Charlotte Department of Transportation

Memorandum

Date: April 30, 2008

Subject: Rezoning Petition 08-081: Located on the northeast corner of Ridge Road and Prosperity Church Road

ILLUSTRATIVE SITE PLAN
SCALE= 1:50

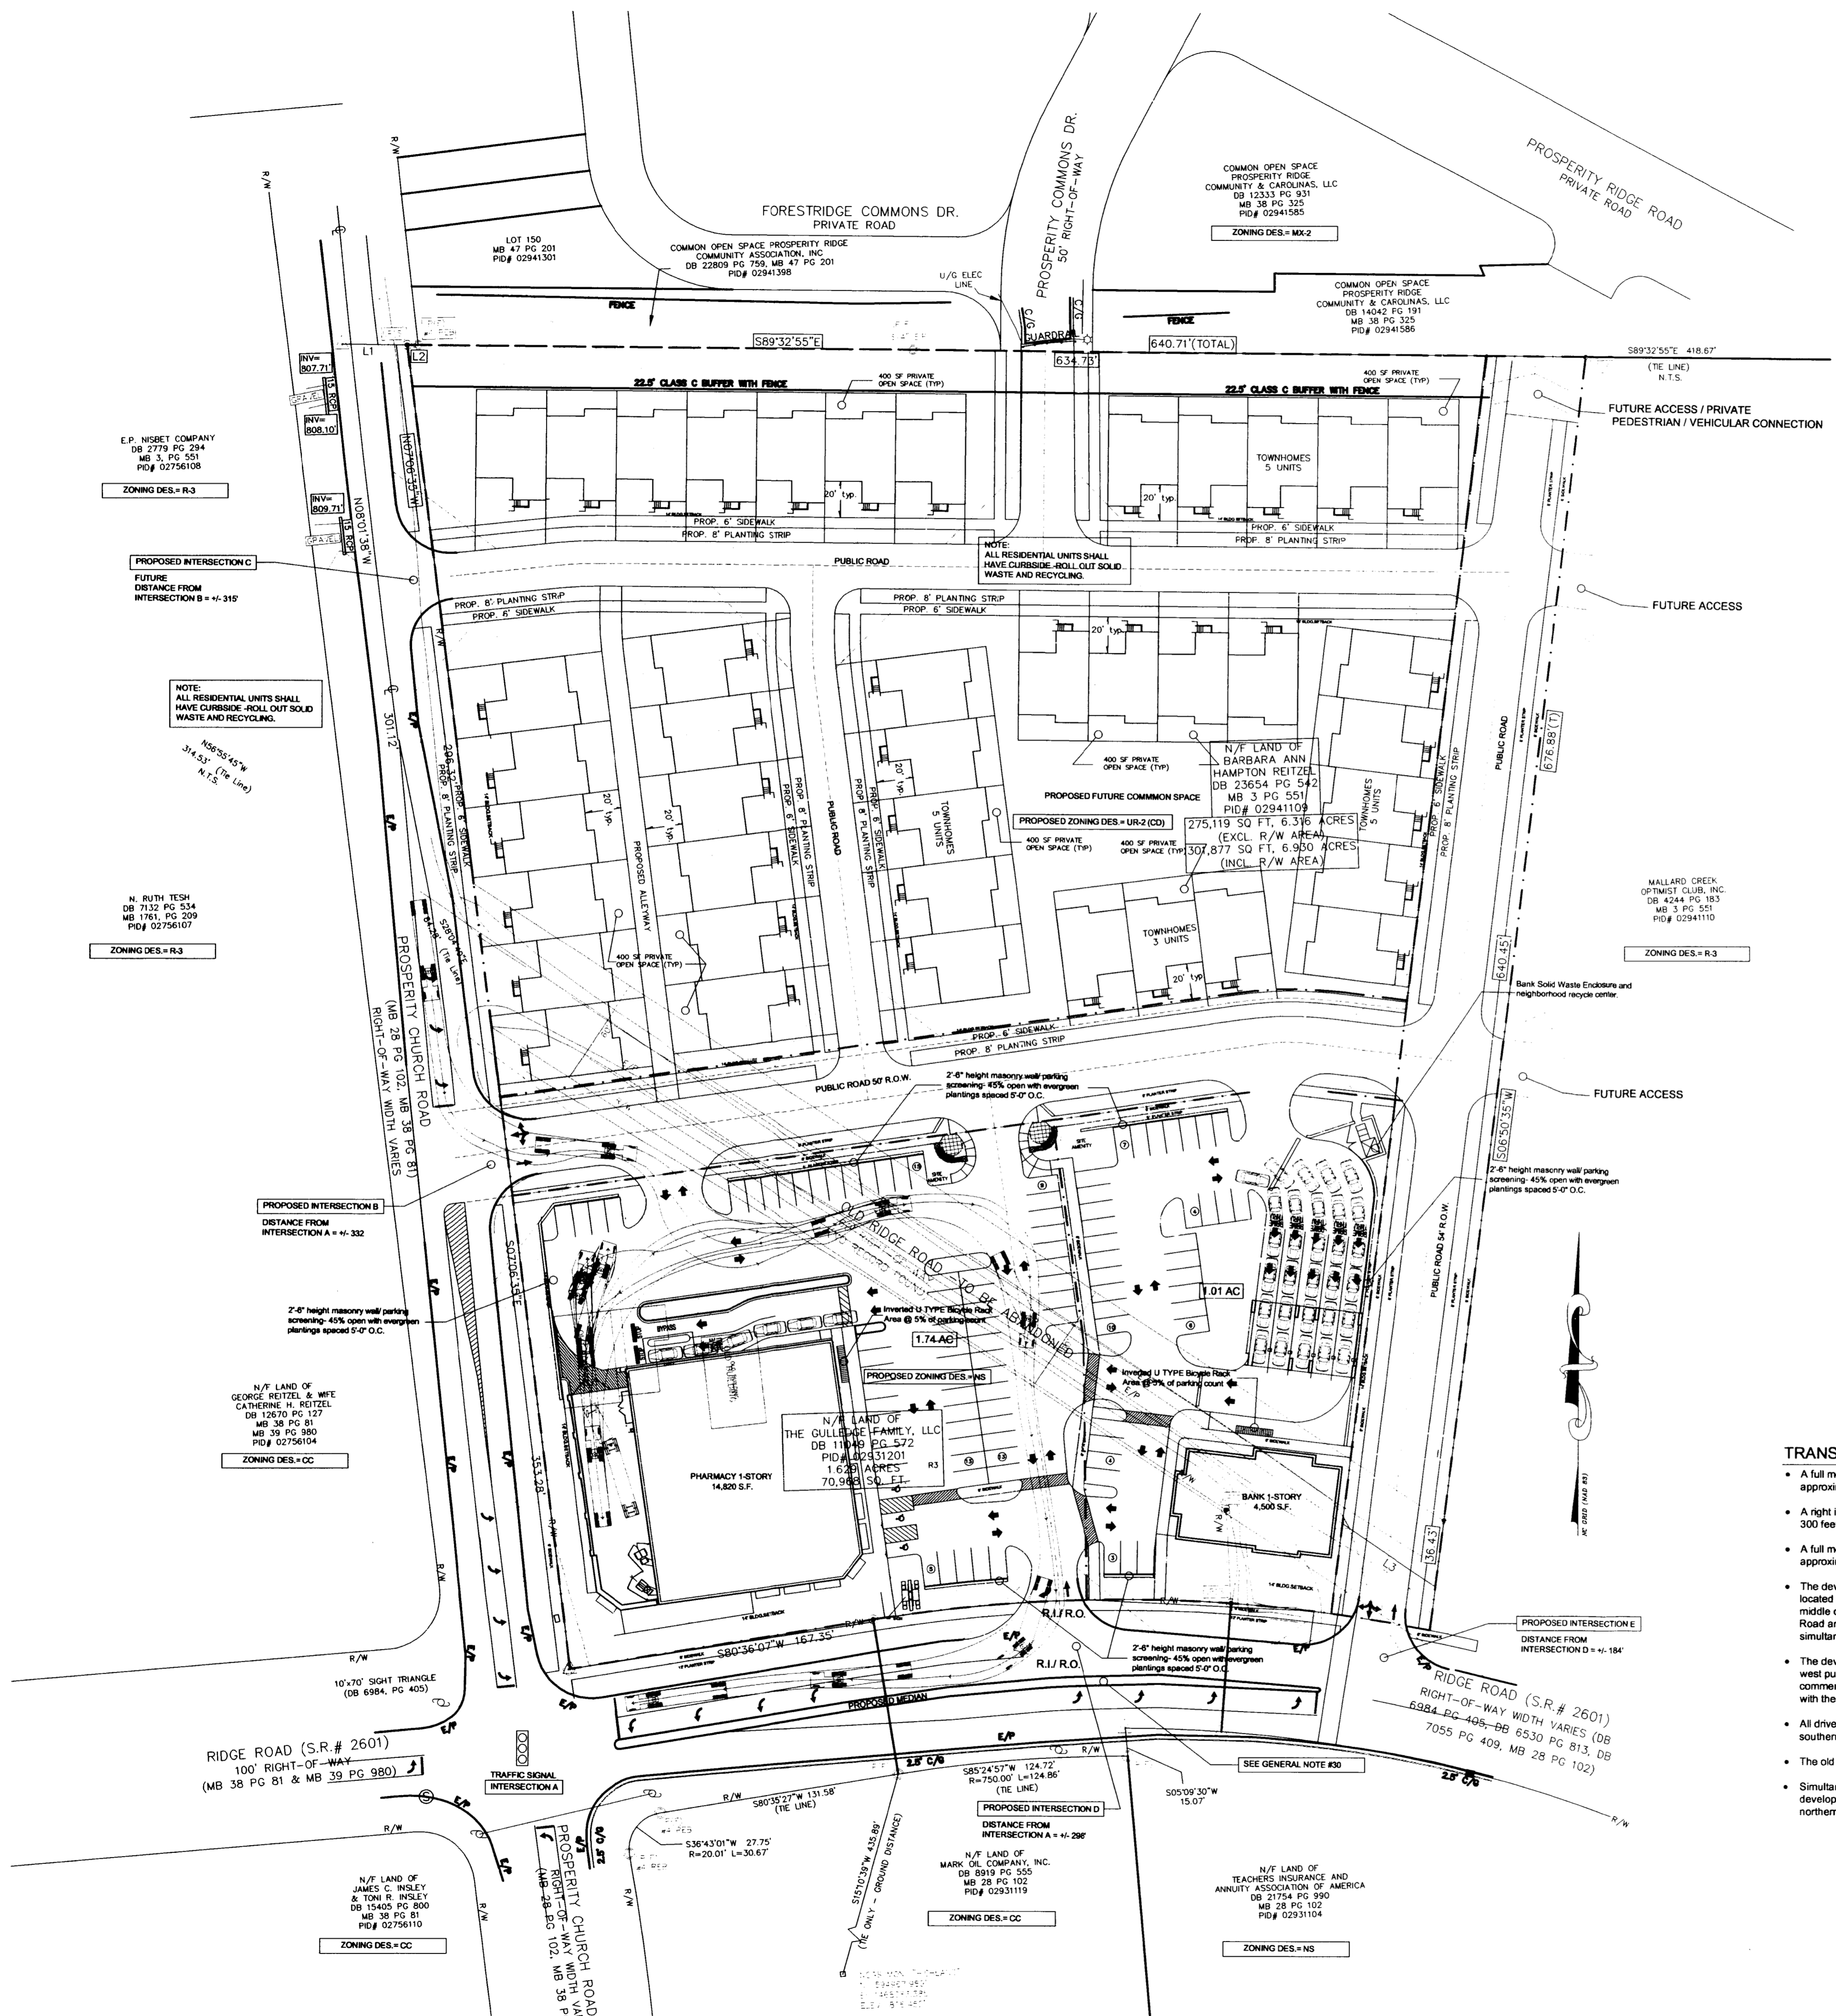
- a. The three proposed accesses to Prosperity Church Road need to be consolidated into two. The current southern and middle access locations need to be removed and replaced with one located between them.

- b. The western proposed access to Ridge Road is deleted.
 - c. An eastbound left-turn lane is constructed on Ridge Road into the proposed access point, with a minimum of 150 feet of storage but otherwise designed to NCDOT standards.

- d. A two-way left-turn lane is constructed on Prosperity Church Road between Ridge Road and Prosperity Ridge Road.
 - e. Old Ridge Road is abandoned.

- f. Curb and gutter corresponding to the ultimate Prosperity Village cross-sections, except as identified above, is installed on the site's Ridge and Prosperity Church Road frontages. This includes removal/relocation of the existing curb and gutter on the north side of Ridge Road.

- g. 8-foot planting strips and 6-foot sidewalks are constructed on all streets, including private streets.
2. The internal driveway to the drugstore closest to Prosperity Church Road will not be approved.

3. The townhomes that front Prosperity Church Road must not have direct driveway access to Prosperity Church Road. Use of rear alleys for these units in particular and the site in general is strongly recommended.

4. The northernmost east-west street is classified as a major collector street stubbed to the east.
 5. The site plan must be drawn to scale.
 6. Label which streets will be public and which will be private.

7. Internal public streets need to be designed as Residential Medium streets.
